STATE OF NORTH CAROLINA
DEPARTMENT OF TRANSPORTATION

February 10, 2015

Subject: **Application Modification Request for USACE Individual Permit, Section 401 Water Quality Certification, Neuse Riparian Buffer Authorization and CAMA Major Development Permit** for the proposed improvement of US 17 from south of Belgrade at SR 1330/SR 1439 to the New Bern Bypass, in Onslow, Jones and Craven Counties. TIP No. R-2514 B, C & D.

References: NCDOT permit application dated November 14, 2014
NCDWR On Hold letter dated January 27, 2015

**PERMIT DRAWING
SHEET 3 OF 84**

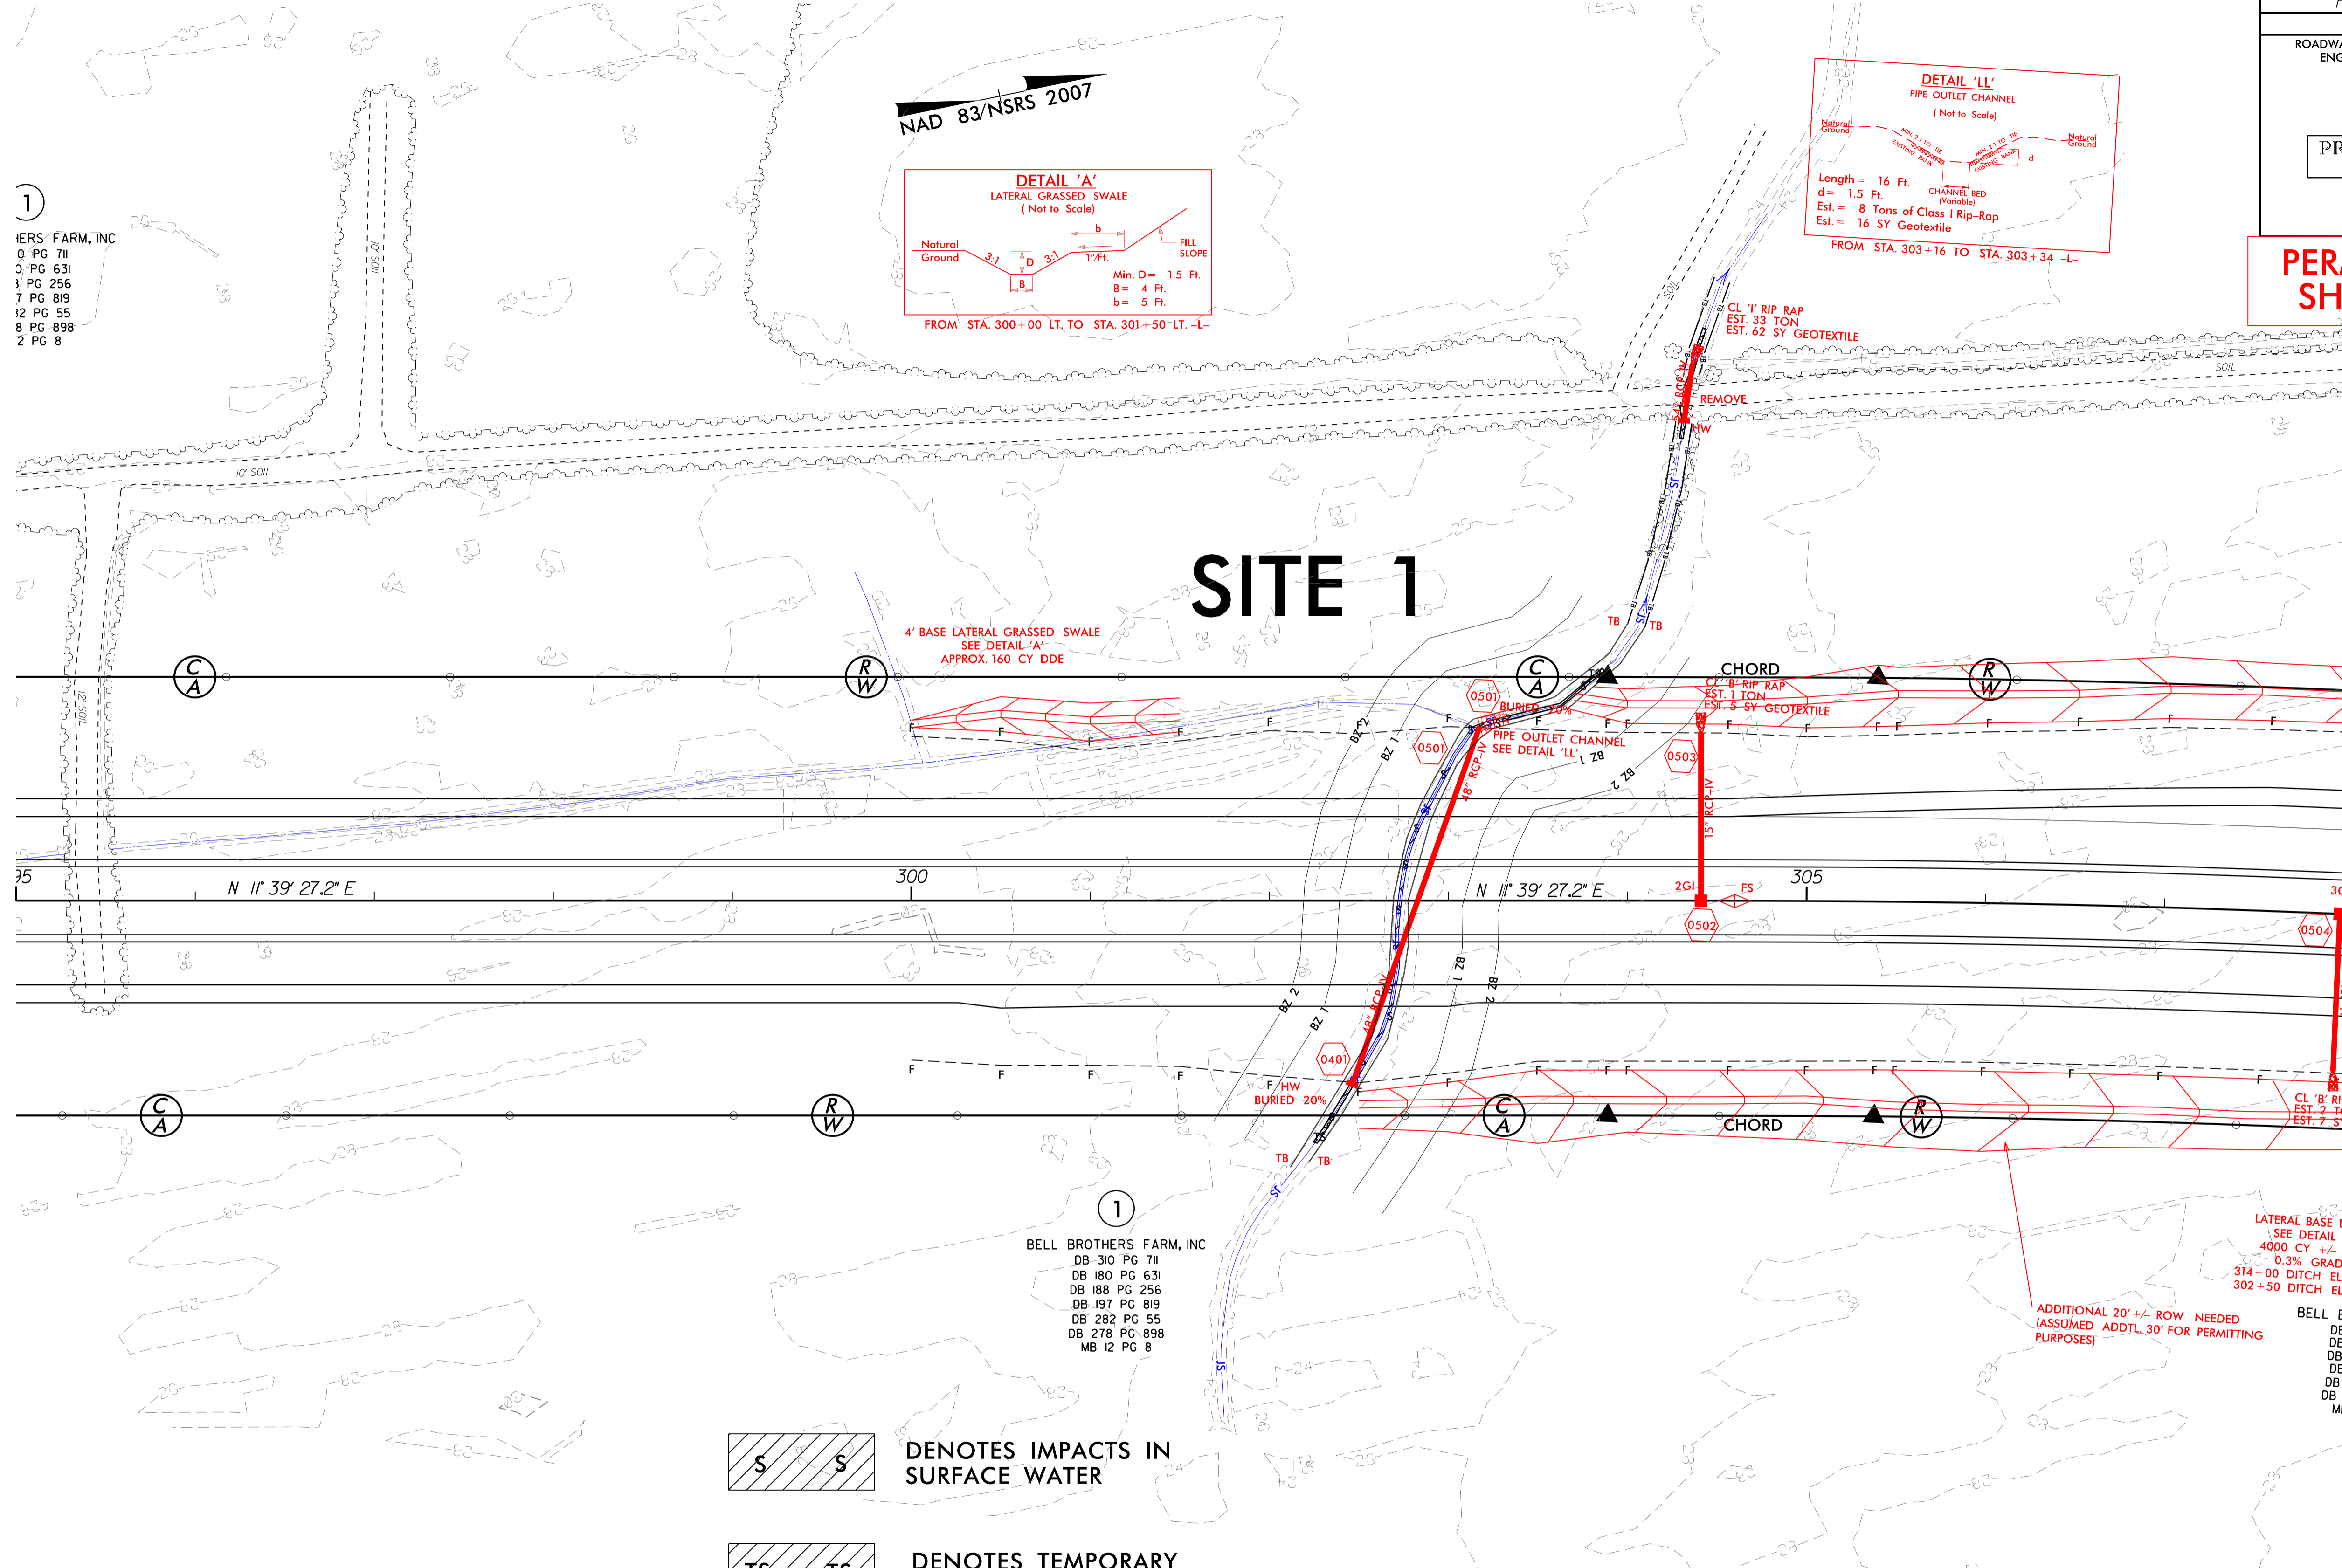
Comments 5 and 6: *Section D – At Utility Site 1 there appear to be power pole/line relocations.*

The amount of hand clearing requested seems to be excessive for the proposed activity. Please explain why this amount of clearing is necessary. At Utility Site 2 the amount of hand clearing requested seems excessive for the proposed utility relocation. Please explain why this amount of clearing is necessary.

Responses to Comments 5 & 6:

Further coordination with the utility companies has reduced the clearing impacts in this area of the project. However, this review revealed an error in the permit application at these impact sites. Specifically, the summary sheet incorrectly lists the impacts at Site 1 and 2 as 0.01 and 0.60 acres respectively, and showed the total impacts as 0.61 acres in the permit application. Utility Permit Drawings Sheet 2 correctly showed that Site 1 impacted 1.259533 acres and Site 2 0.5993 acre, a total of 1.86 acres. The Utility Permit Drawing data was incorrectly transferred to the summary sheet.

The revised drawings included in this submittal show a much reduced footprint; with Sites 1 and 2 impacting 0.35 and 0.40 acre due to hand clearing. This reduced the impacts from 1.86 acres to 0.75 acre.
